Office of
Environment
& Heritage

Our Ref: DOC18/682791

Your Ref: SSD 8169

Re: Environmental Impact Statement – State Significant Development 8169 and Modification 3 of Major Project 09_0028 (Concept Plan) for North Byron Parklands Cultural Events Site, Yelgun

Figure 3: Primary and Secondary Koala Habitat (arrows represent generalised Koala movement corridors)

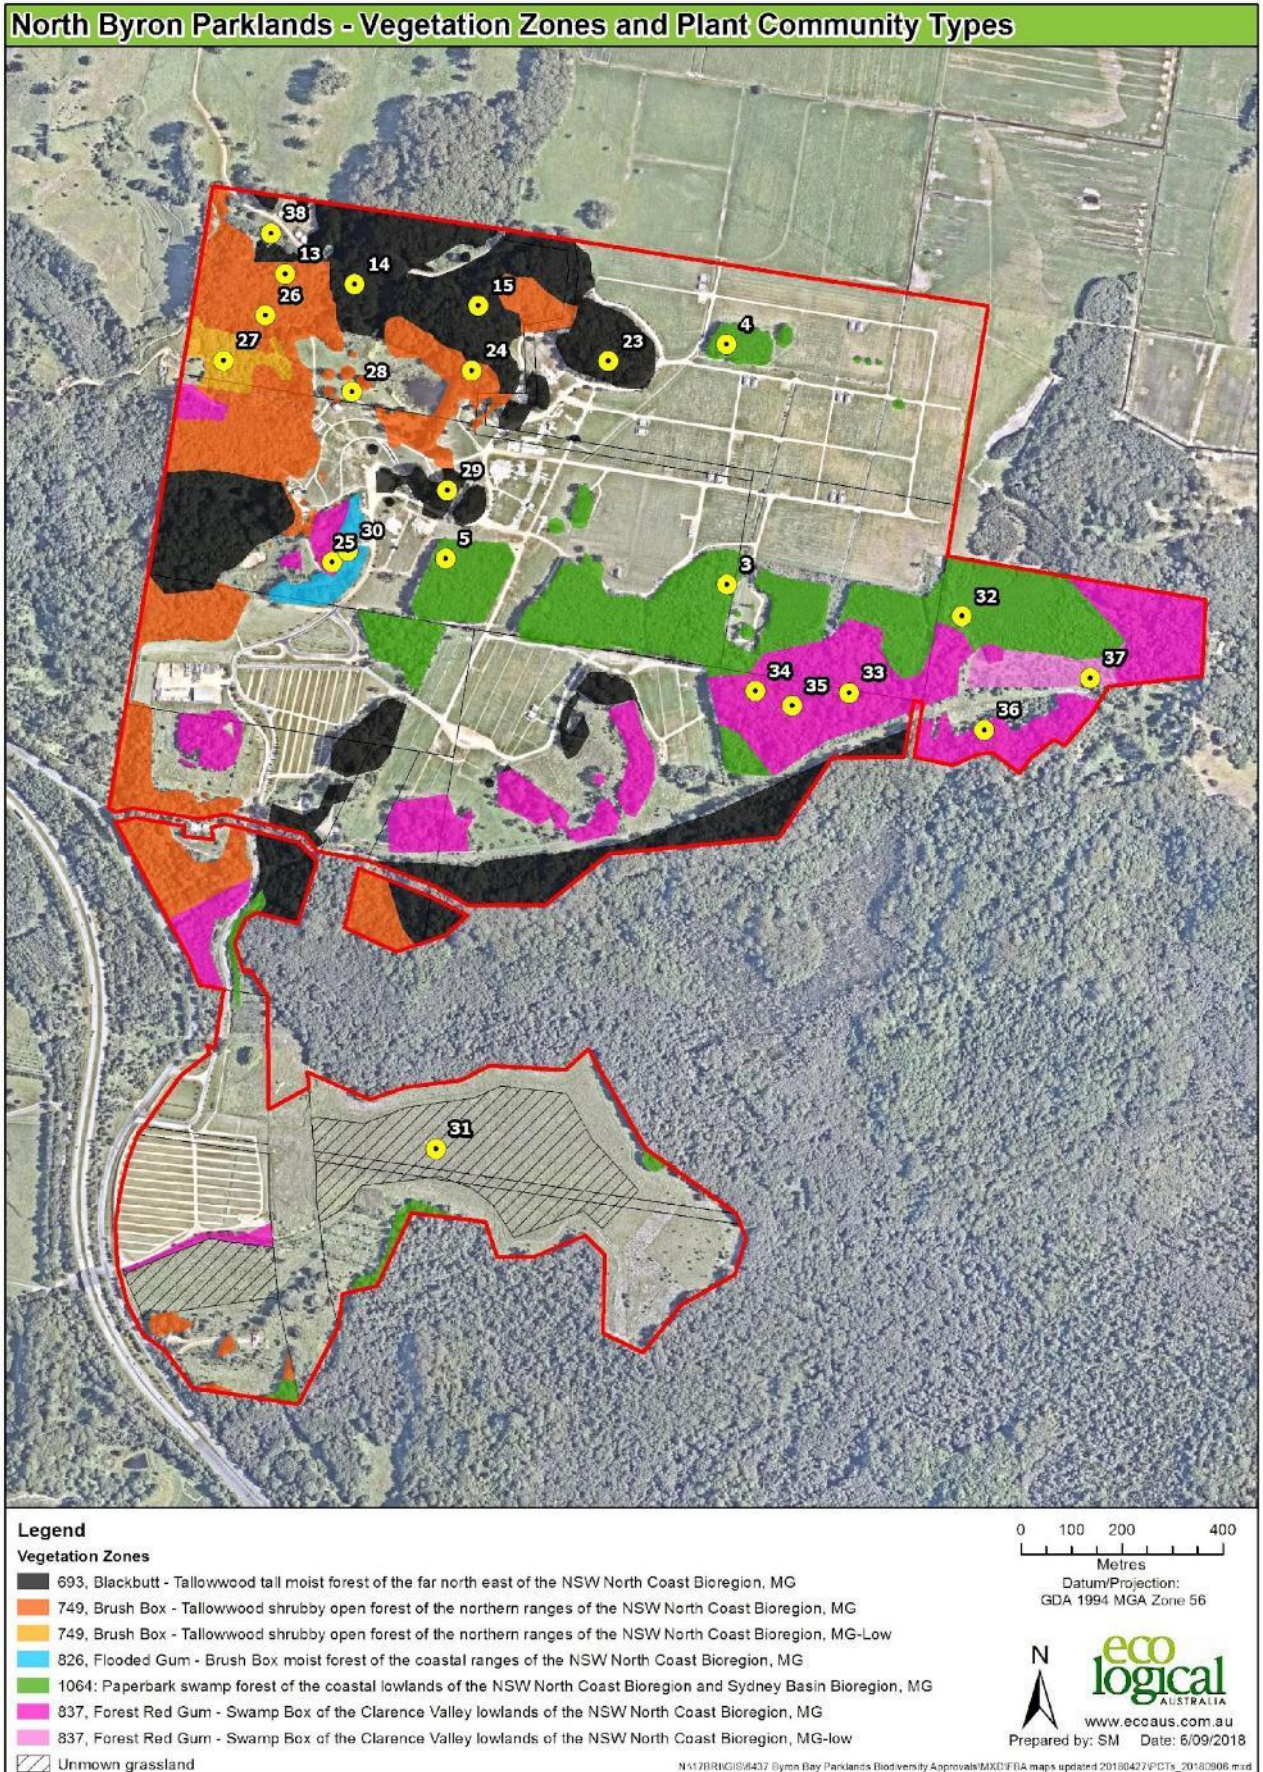
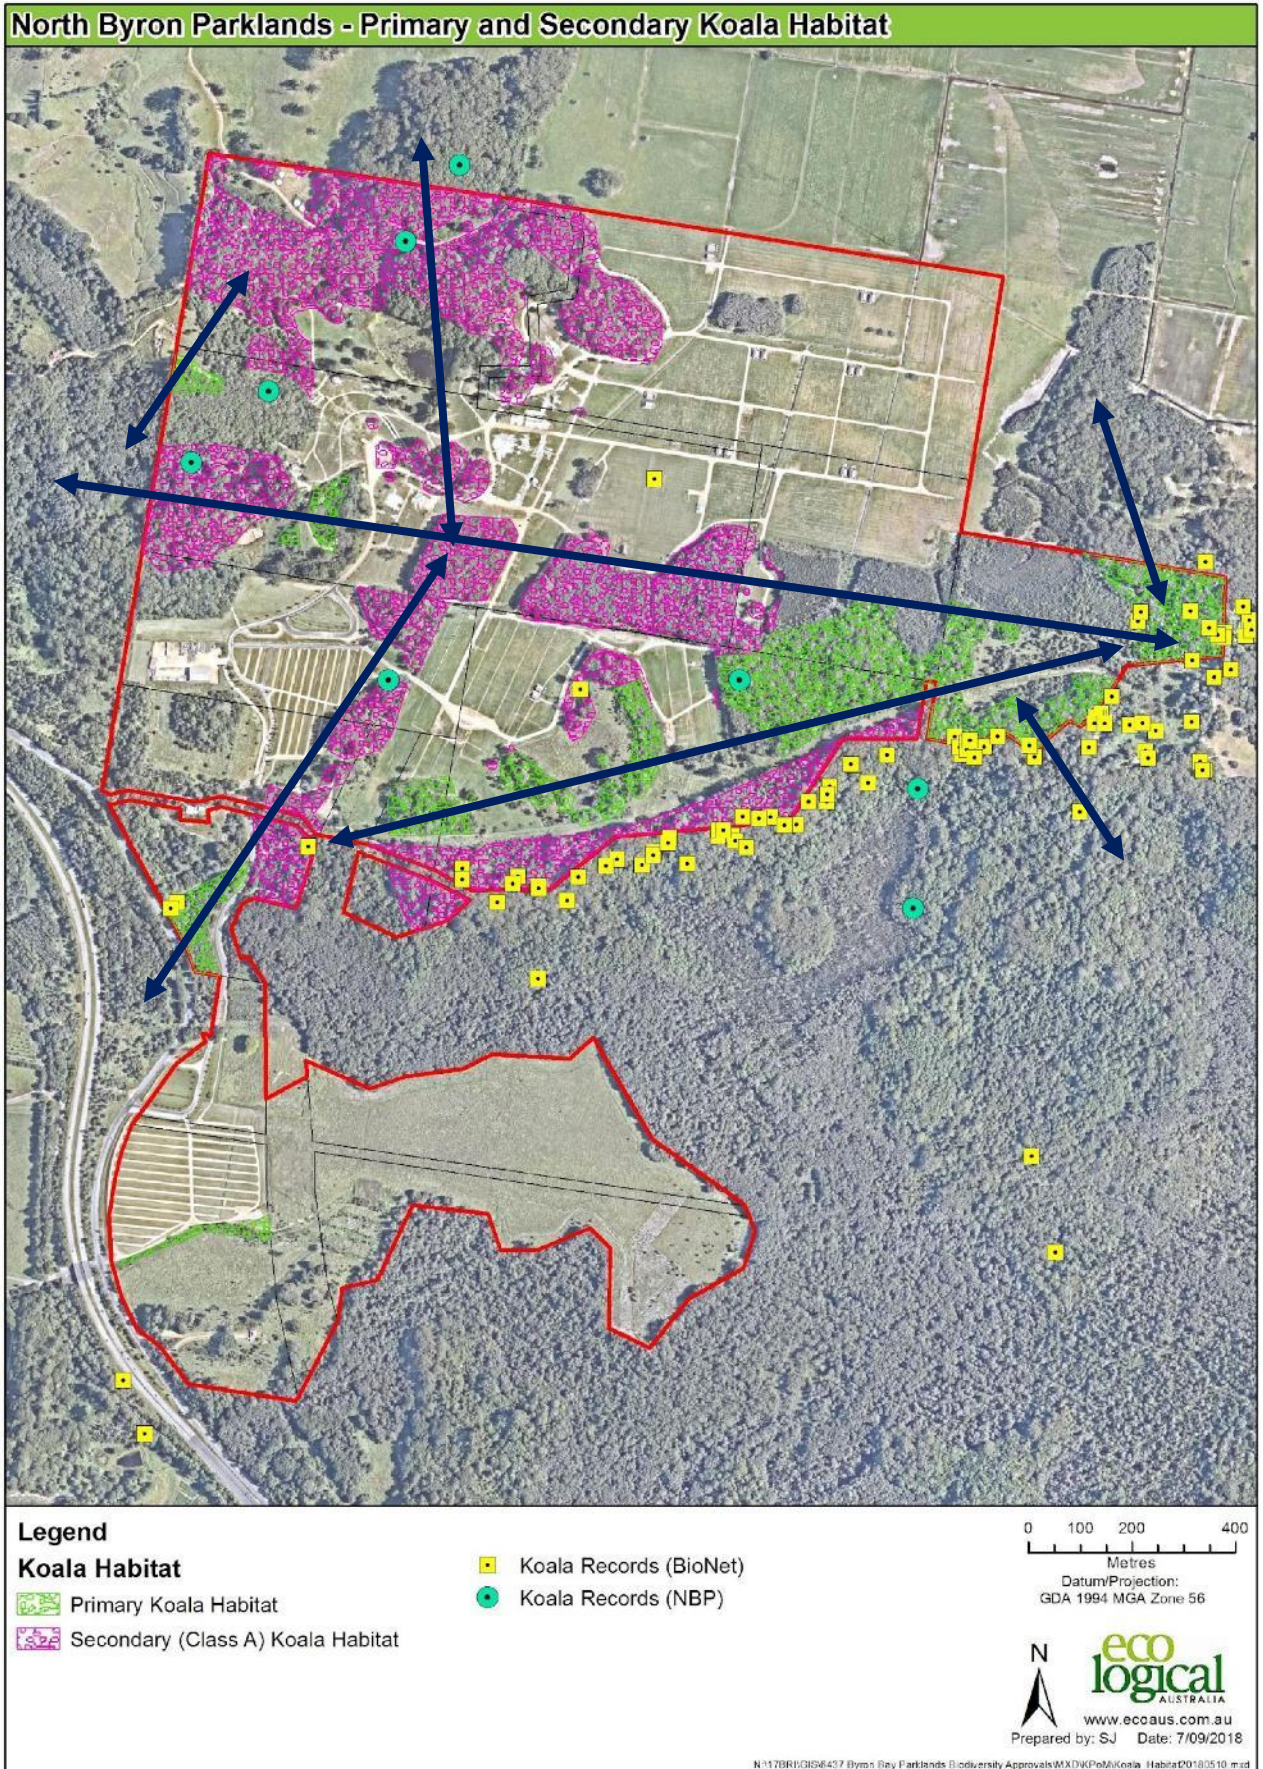
1. Requires the applicant to provide the following information in the KPoM before the application is determined:
 - a. Accurate vegetation and koala habitat mapping that reflects the applicant's most recent changes in mapping of forest red gum dominated plant community types;
